CITY OF ALBUQUERQUE

RE: **SAD 228 Residence**
6601 Cuervo PL NW
Request Permanent CO - Accepted
Engineers Stamp Date 5/27/15 (D10D003J7)

**RE: SAD 228 Residence
6601 Cuervo PL NW
Grading and Drainage Plan
Engineers Stamp Date 5/11/15 (D10D003J7)**

Based upon the information provided in your submittal received 5/19/2015, the above referenced Grading and Drainage Plan cannot be approved for Grading Permit or Building Permit until the following comments are addressed.

SITE PLAN

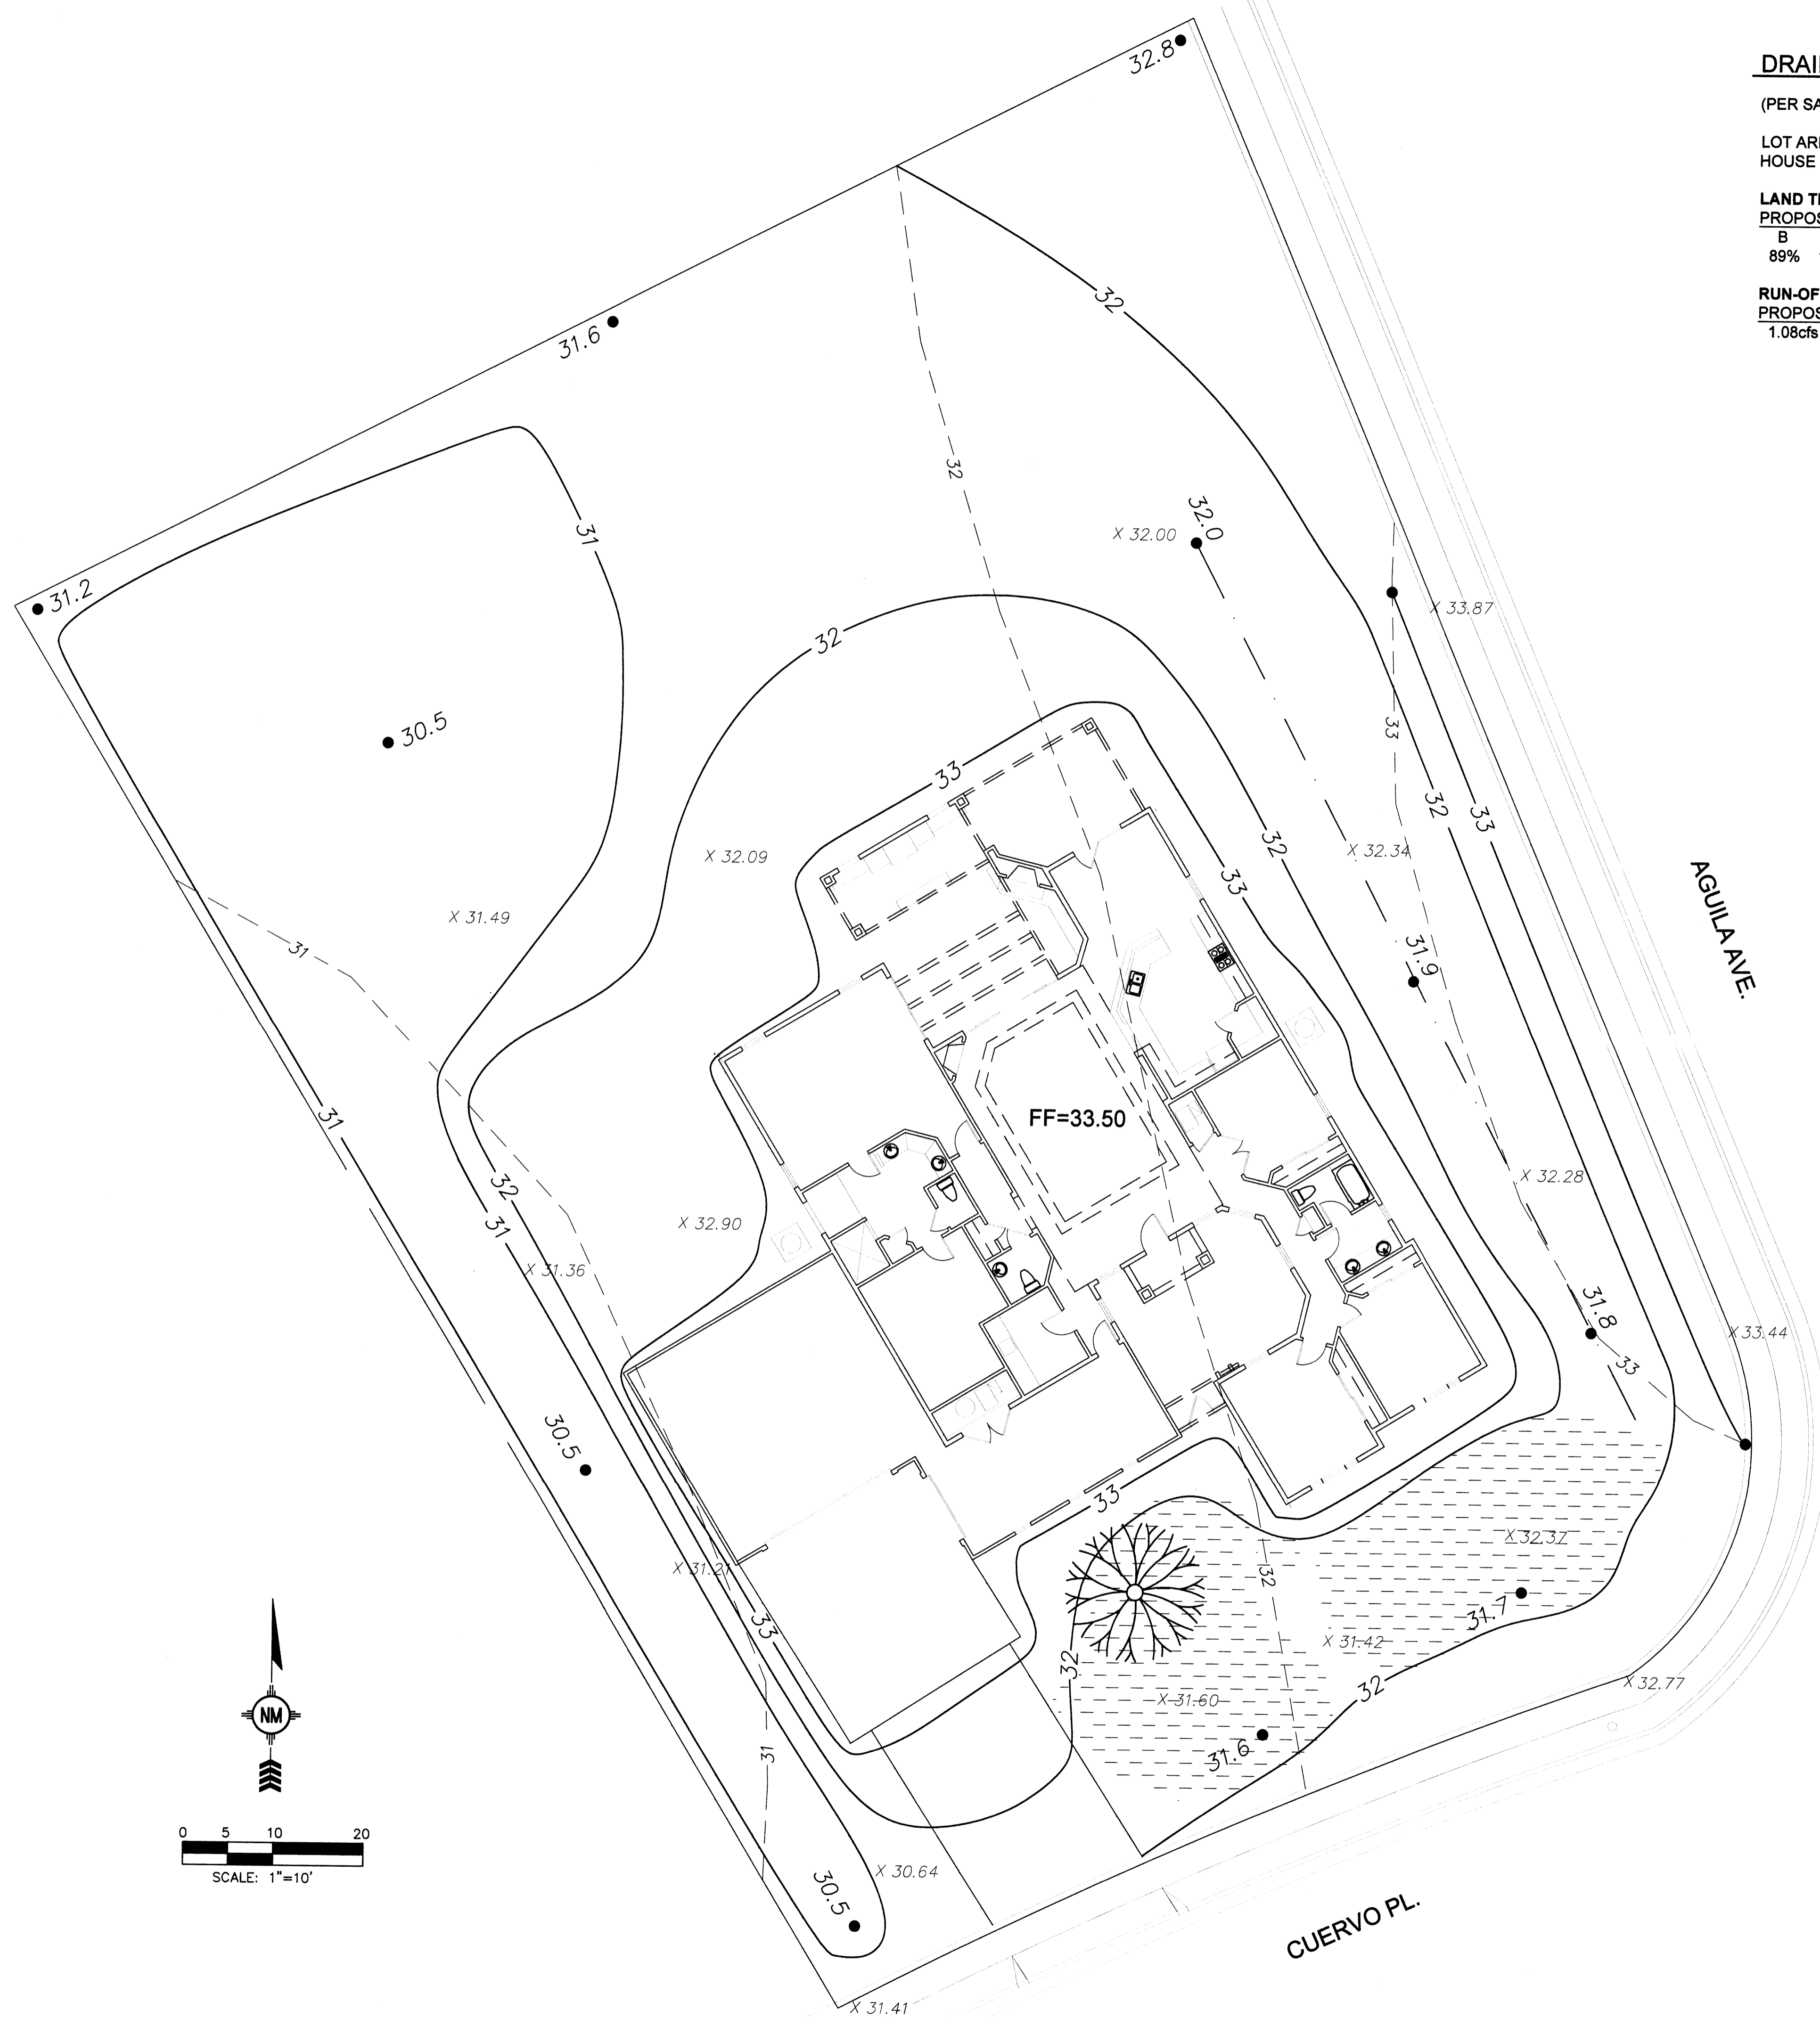
- ✓ Provide a site plan and FIRMette of this location.
- ✓ Provide a table of calculations for land treatments, percentages, existing and proposed flows.
- ✓ Provide a legal description of this site.
- ✓ Show or mention the location of the bench mark. 170-10

Please
See supplemental information to revise plan
for addressing of comments
